HOTEL BUILDING 2 EXTENSION PLANNING APP

APP NO: 3782 - Erection of a single storey extension to create a spa centre

Rev	Date	Note
P1	02-09-25	PLANNING ISSUE
PROJECT		
Tudor Lodge Hotel, 50 Field End Road HA5 2QN		
DRAWING TITLE		
PLANNING RESPONSE MARCH 2023		
STATUS		
PLANNING APPLICATION		
DRAWN BY	Author	CHECKED BY Checker

EXISTING ELEVATION 1 OF 2

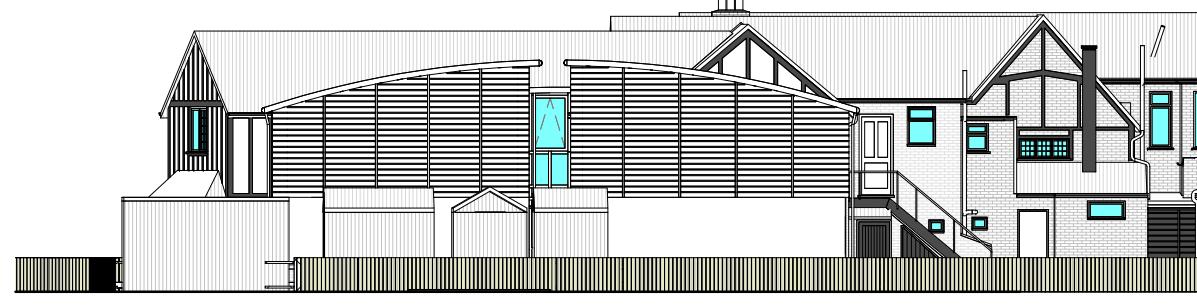
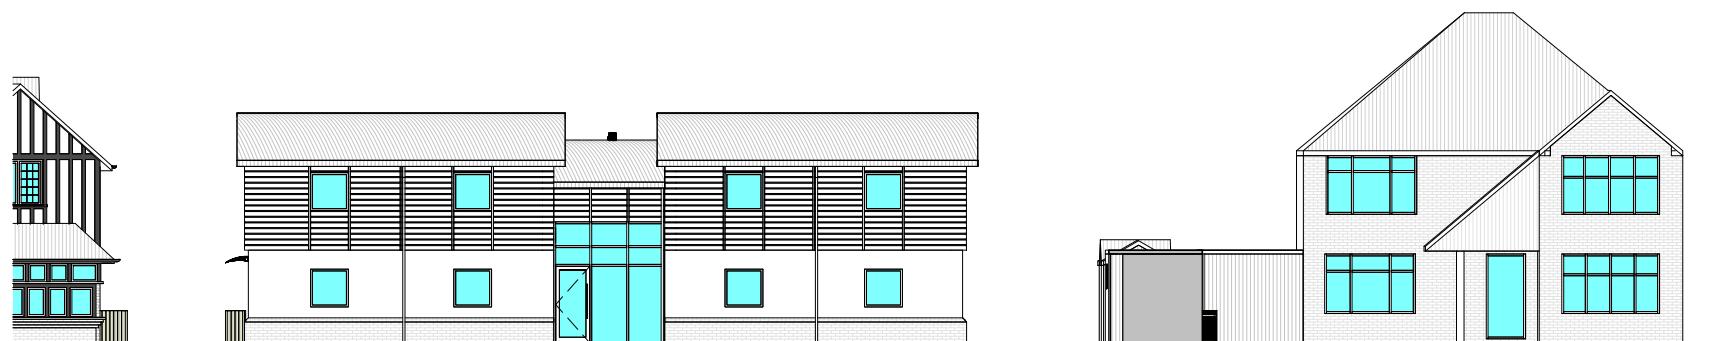
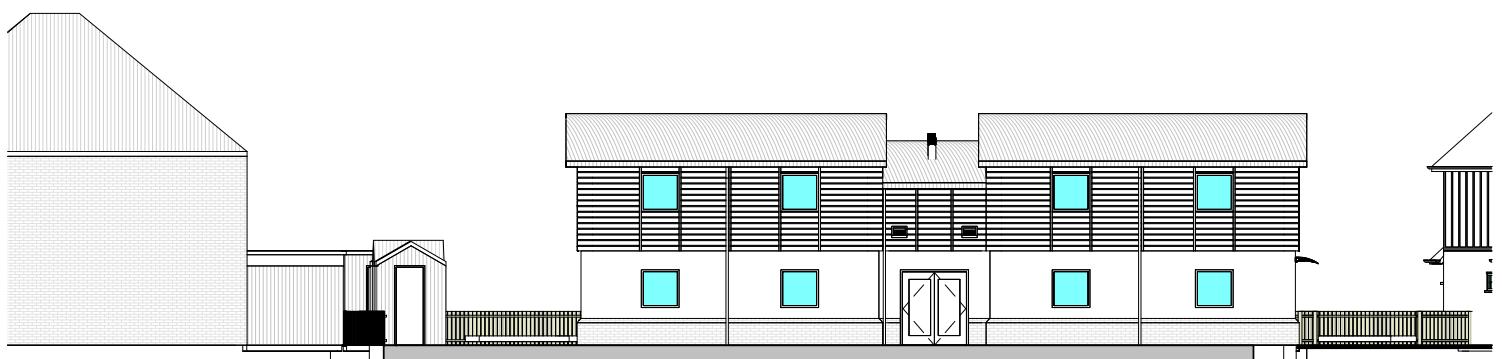
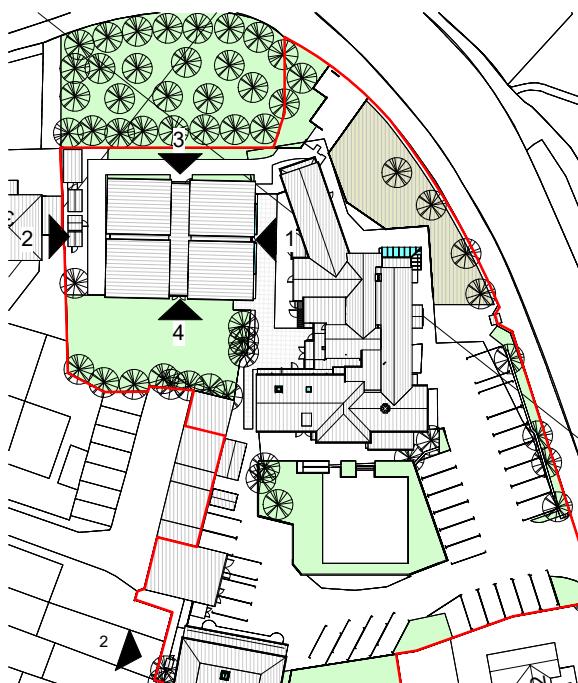
PLANNER COMMENTS: I have issue with the combined issues of the setback from the boundary and the projection forward of what would be the building line as measured to No. 34 in terms of dominance and a departure from the building line

DESIGN RESPONSE: proposed extension is in the same position of existing shed and back up against no.34 side extension. The rear portion of the proposed extension is set back from boundary. The overall extension height is reduced to 2.5 meter with footprint reduced / setback from boundary. The extension entrance design is update to a glassbox design (photo 1). The extension is hidden away from view as
